# SITE DEVELOPMENT PLAN

## LOT 2, GREATER EUROPE MISSION SUBDIVISION FILING NO. 1

SITE DEVELOPMENT PLAN  
**MONUMENT STEEL STRUCTURES**  
 COVER SHEET  
 18910 BASE CAMP ROAD  
 MONUMENT, COLORADO

# Site Development Plan\_v1-redline.pdf Markup Summary

BUILDING 1

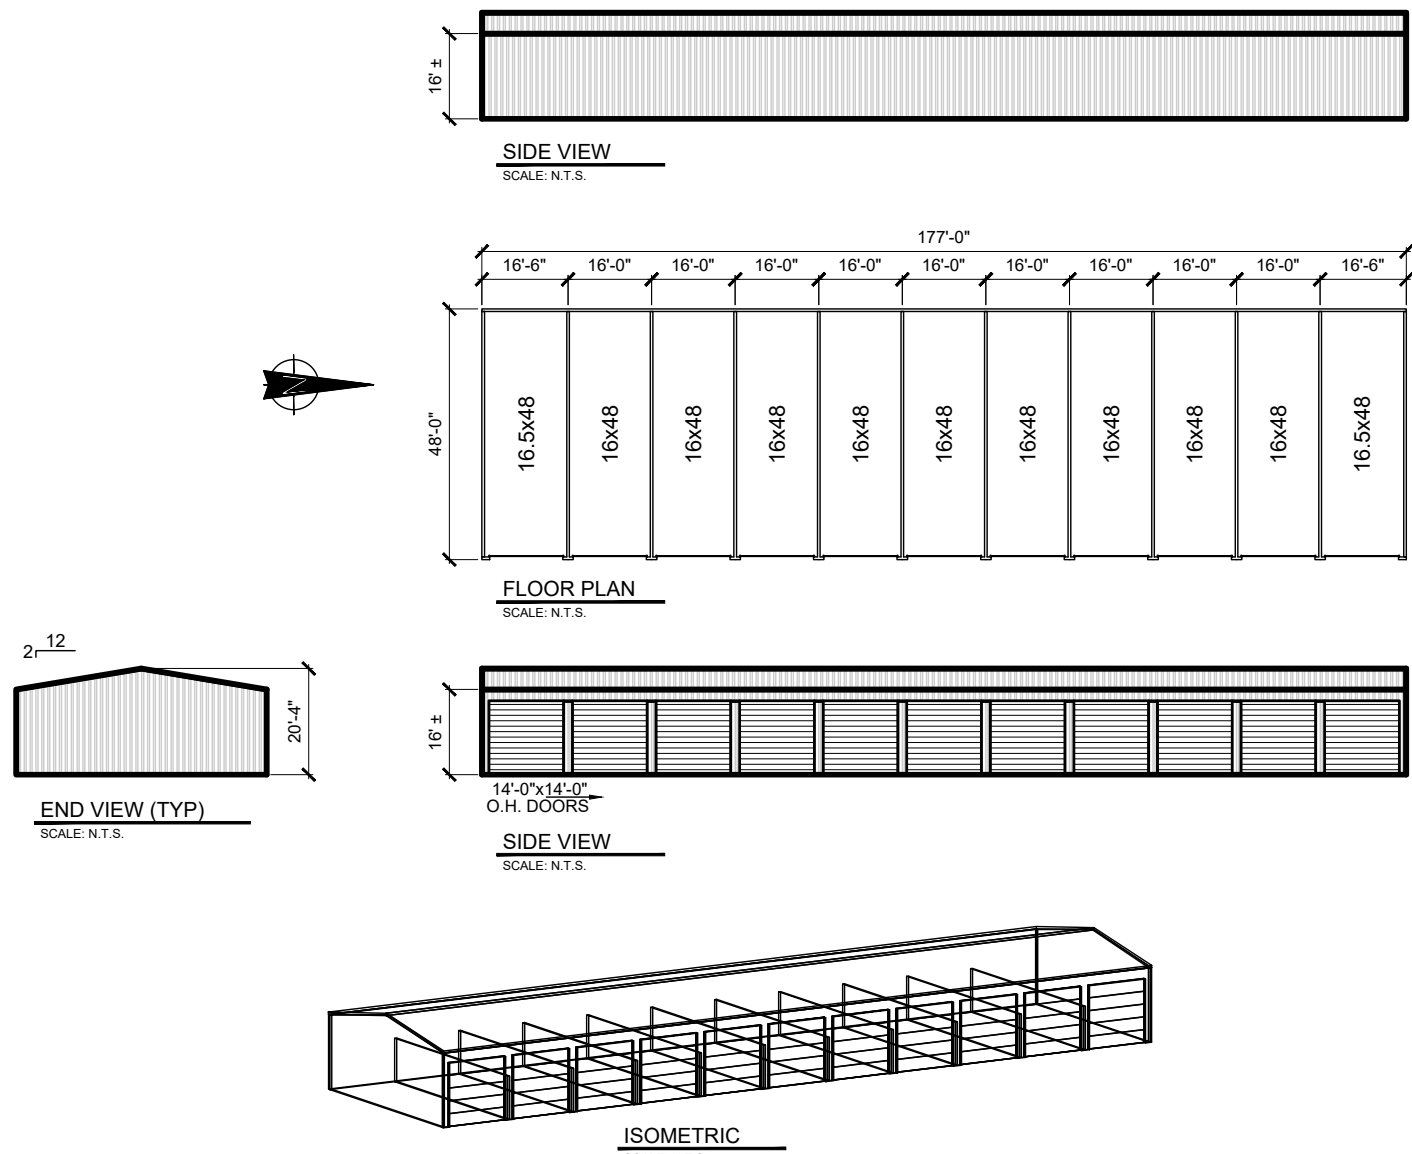
Include floor plan dimensions on floor plans in order to calculate parking ratio.

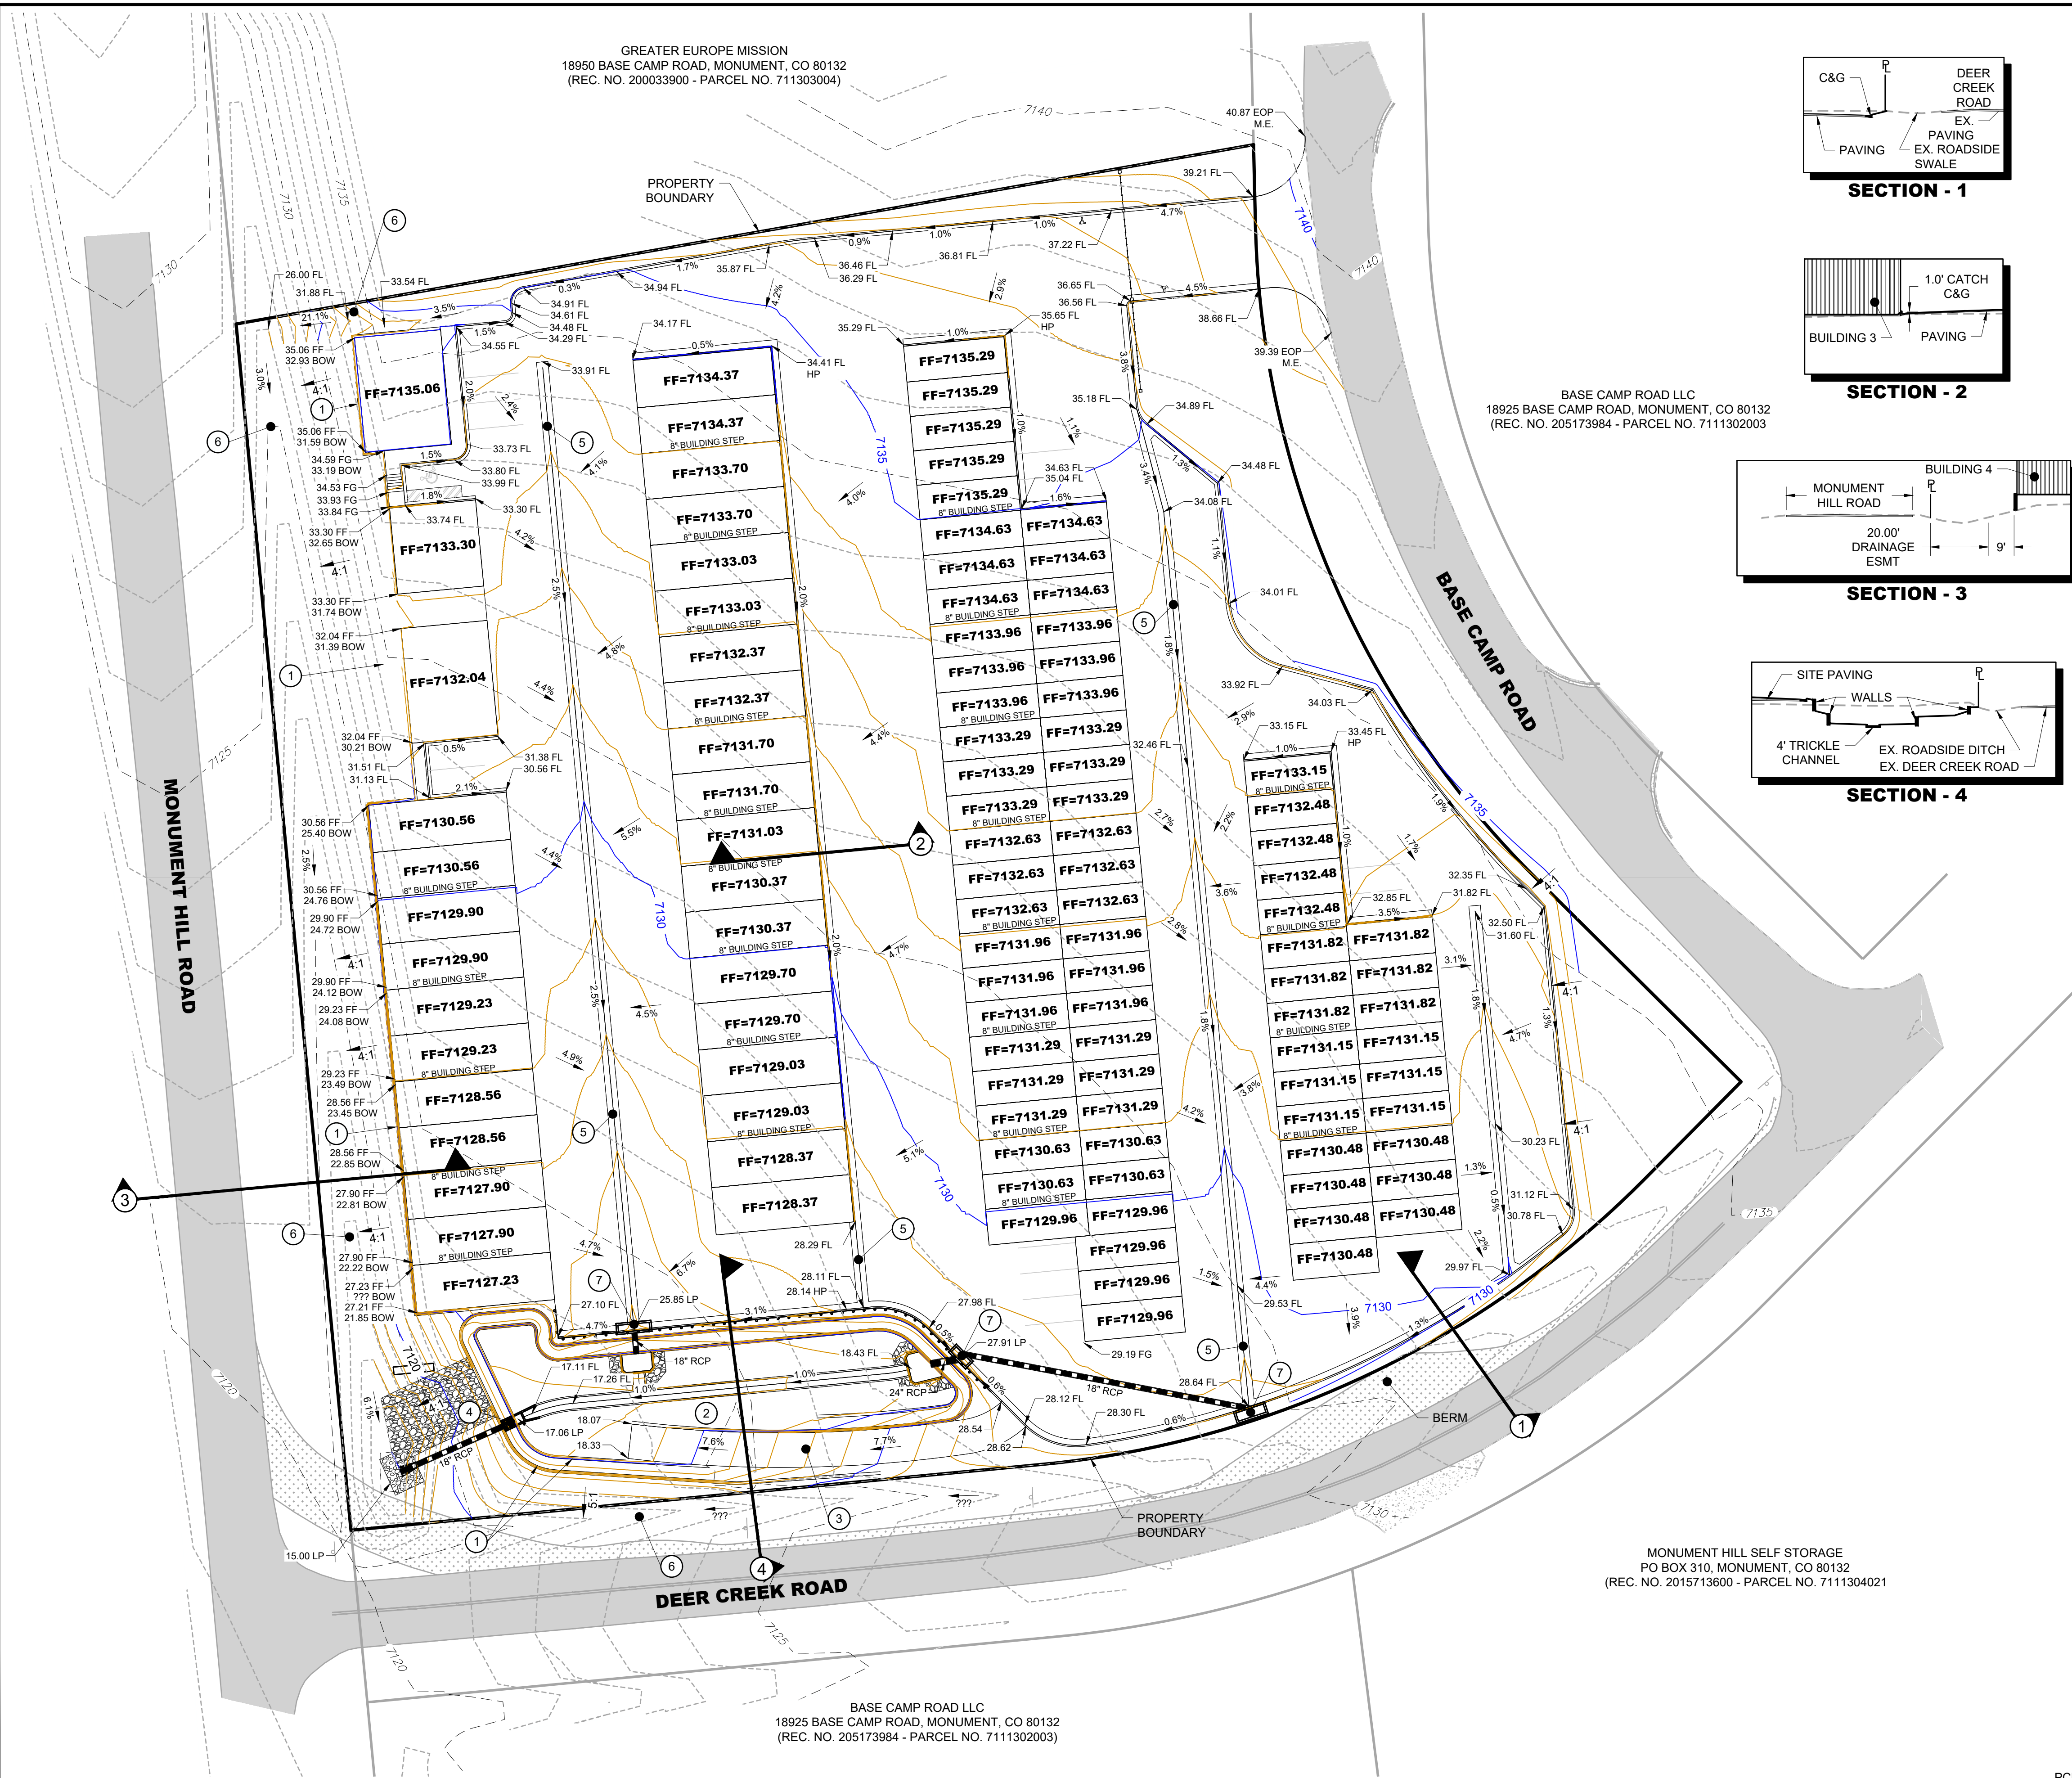
**Subject:** Callout  
**Page Label:** [2] 2 SITE AND UTILITY PLAN  
**Lock:** Unlocked  
**Author:** dsdlaforce  
**Date:** 5/20/2019 11:55:06 AM  
**Status:**  
**Color:** ■  
**Layer:**  
**Space:** Provide curb detail of the standard and modified curb&gutter

Provide detail for transition from C&G to edge of asphalt. Curb and Gutter shall end at the property line.

Show a parking plan, how many spots are required vs proposed, including additional ADA spots. Show a route from the ADA parking spot to the building.

Show definitive setback.

Show the intersection sight distance triangle. Reline is approximate only, see Engineering Criteria Manual Section 2.3.6.G for determining sight distance triangles. Add a note stating any object within the sight distance triangle more than 30 inches above the adjacent road edge of asphalt shall constitute a sight obstruction, and shall be removed or lowered.

Show trash enclosure and a detail of it.

The following note should be added to all site development plans or non-residential site plans, as applicable, prior to PCD approval:  
The parties responsible for this plan have familiarized themselves with all current accessibility criteria and specifications and the proposed plan reflects all site elements required by the applicable ADA design standards and guidelines as published by the United States Department of Justice. Approval of this plan by El Paso County does not assure compliance with the ADA or any regulations or guidelines enacted or promulgated under or with respect to such laws.

These curb radius seems larger than necessary. Revise to 20' (ECM Section 2.3.7.F Table 3-31).  
Traffic Impact study to provide a recommendation. If larger than 20' is required then provide an Autoturn exhibit.
